ABERT RANCH

PRELIMINARY GRADING & EROSION CONTROL PLAN

Markup Summary

C1

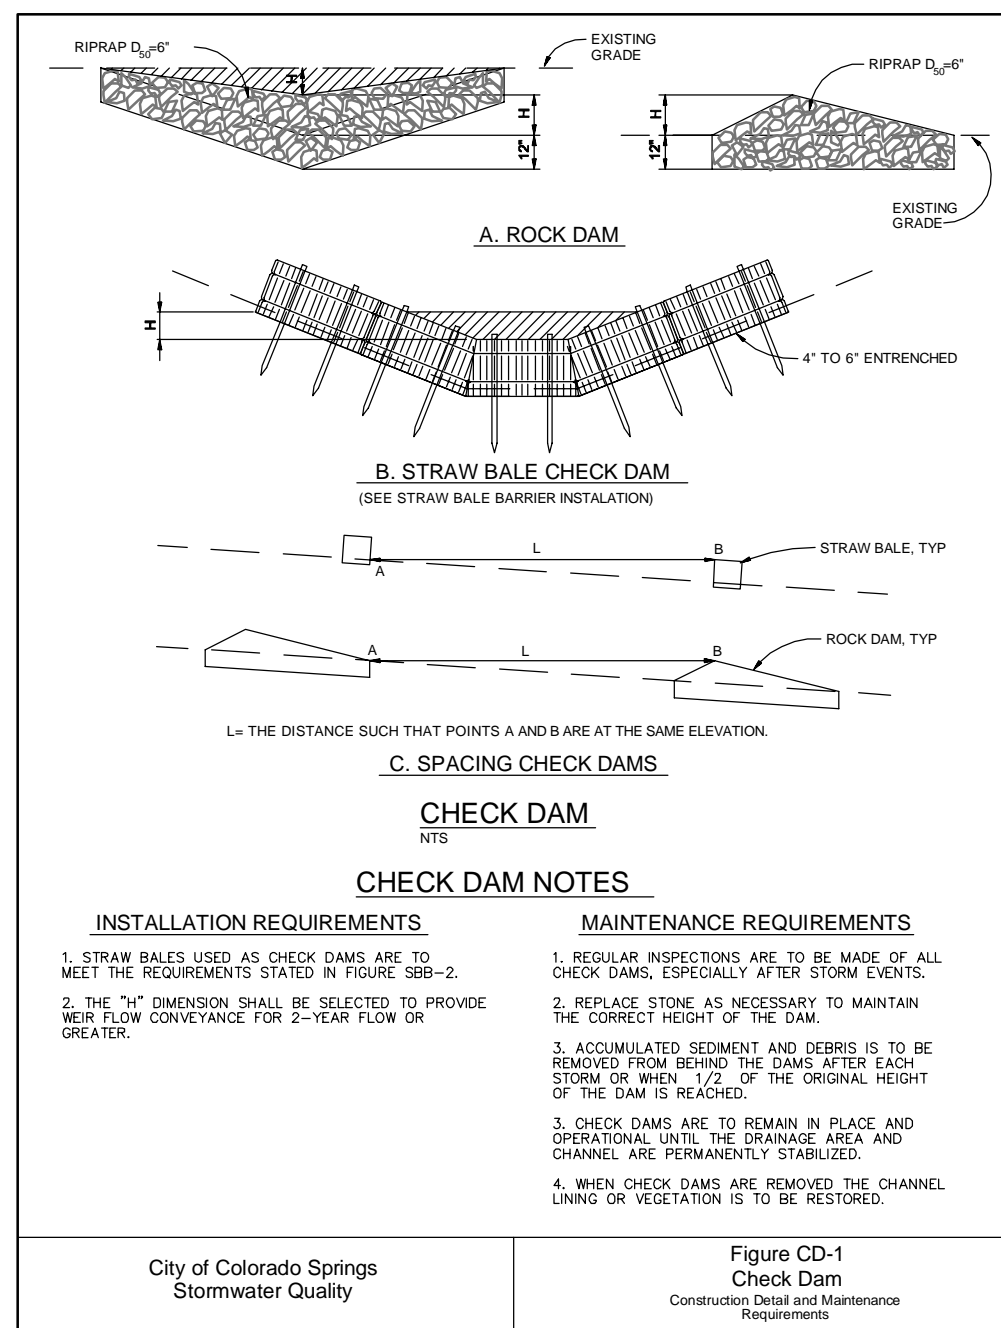
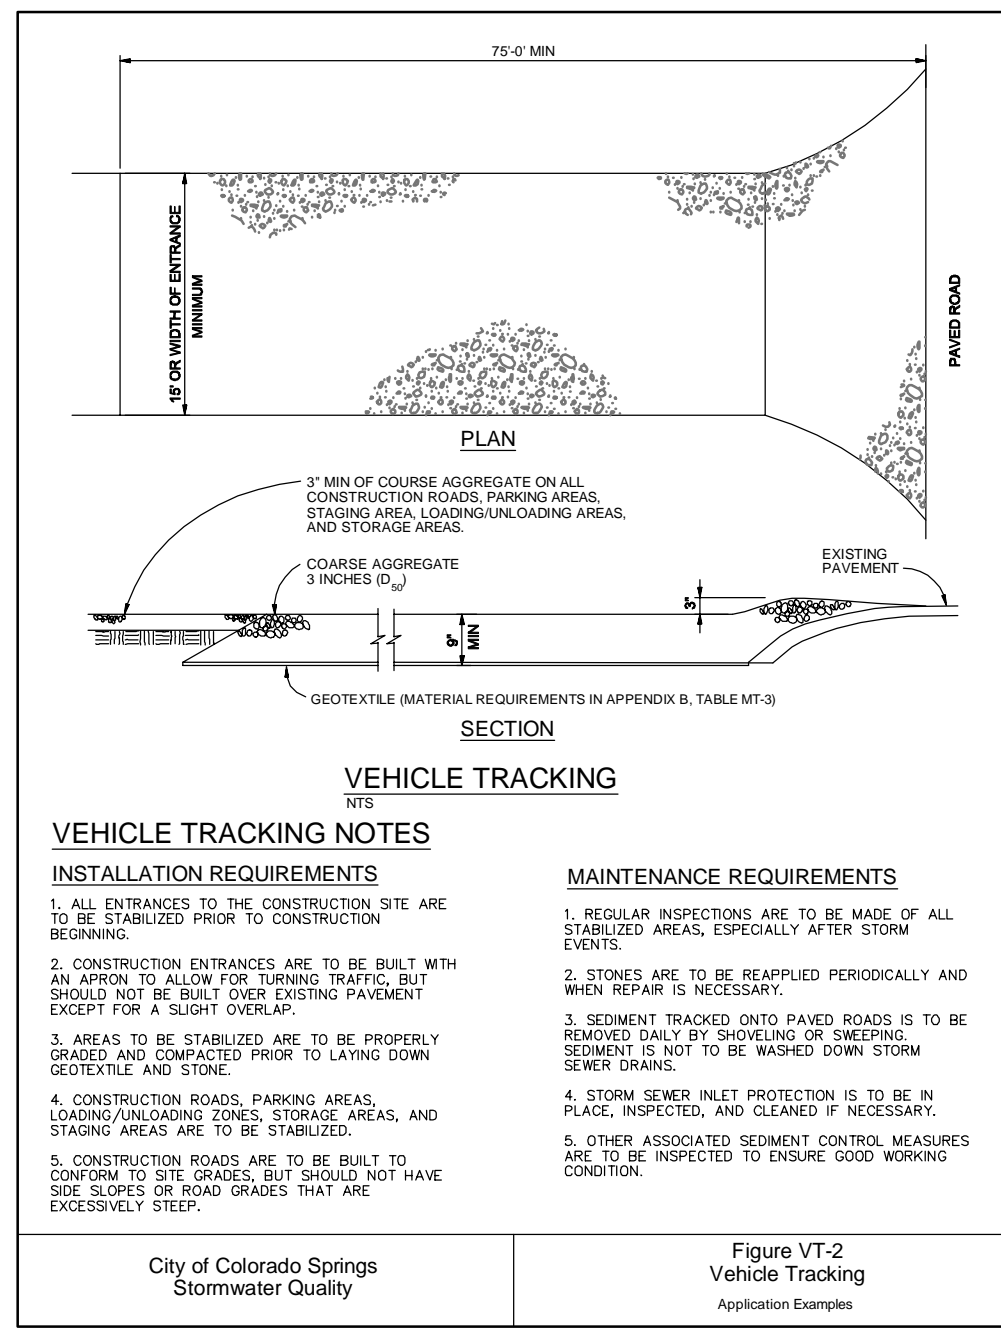
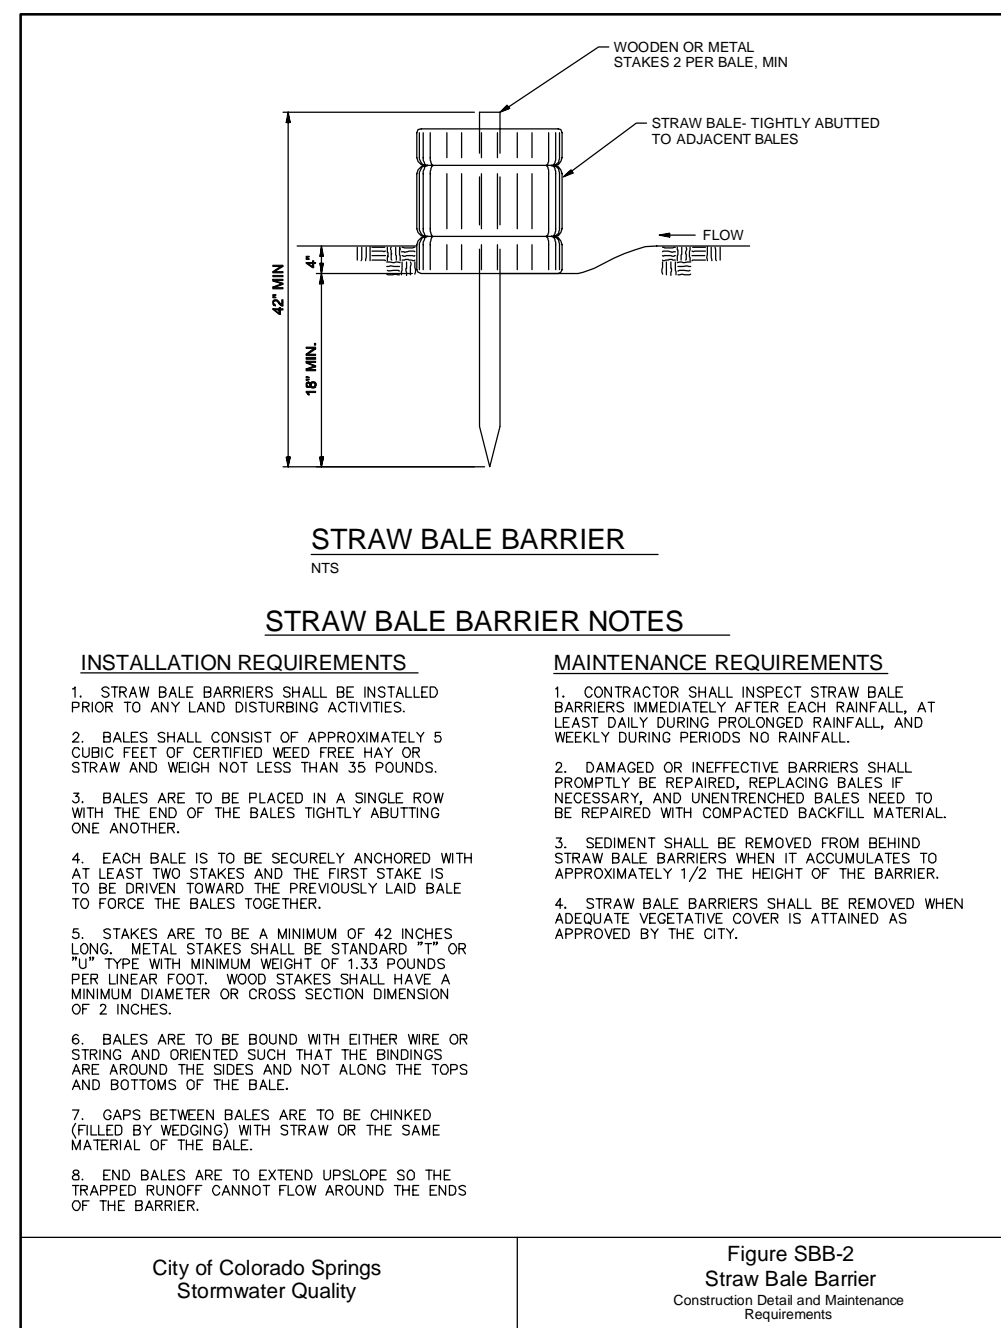
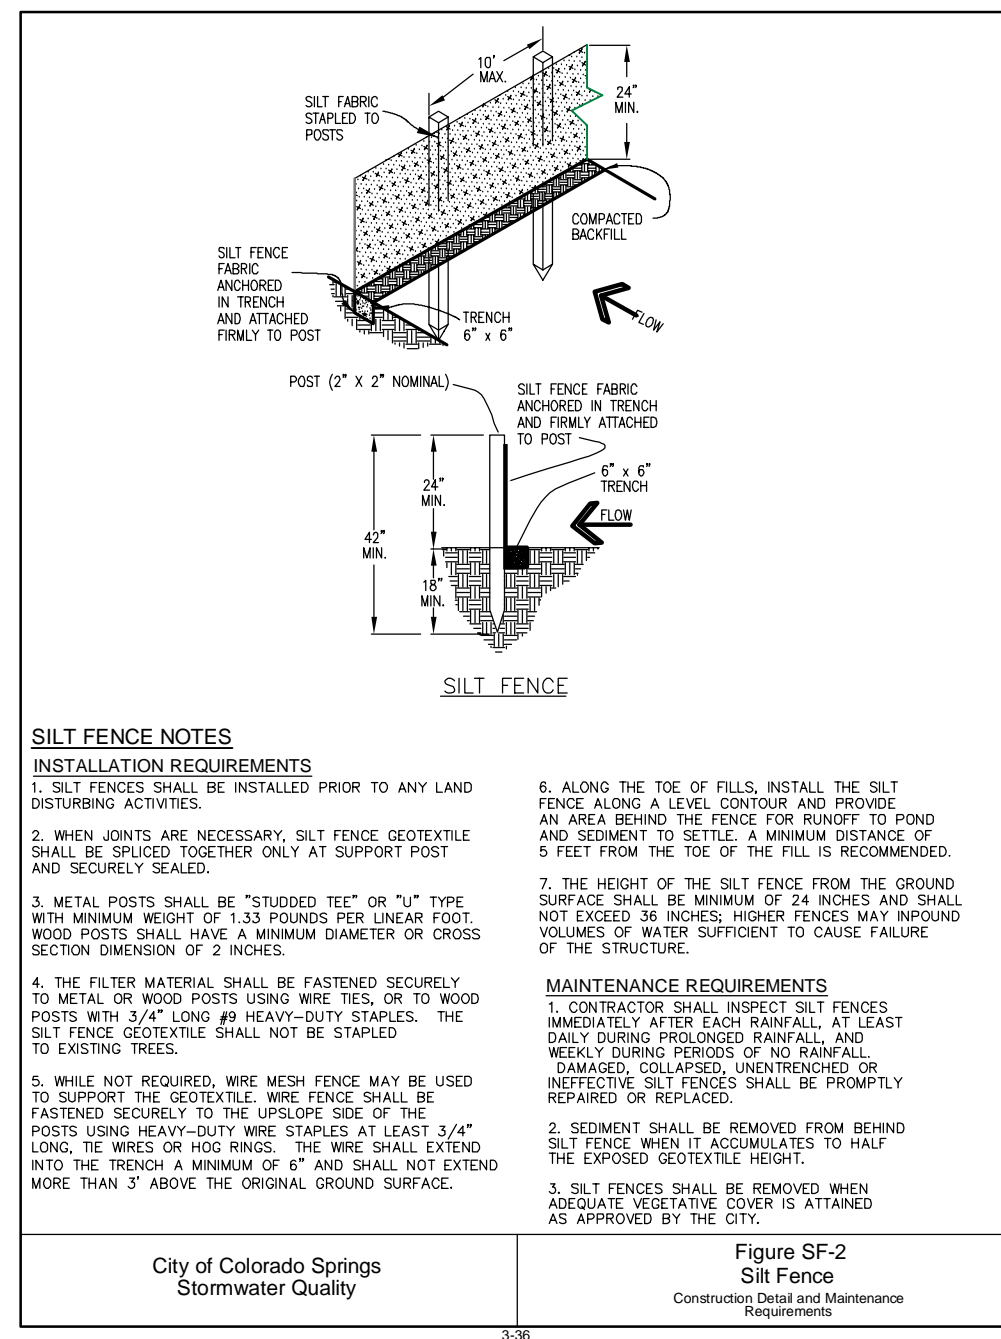
Are you asking for early grading? If so add to the letter of intent and submit a financial issuance form.

Include this area within a drainage easement.

Show the access easement to the detention pond.

Provide a drainage easement for the roadway and offsite basin D12 runoff.

Label and show proposed grading for the temporary emergency access. A culvert is likely required at the access point.
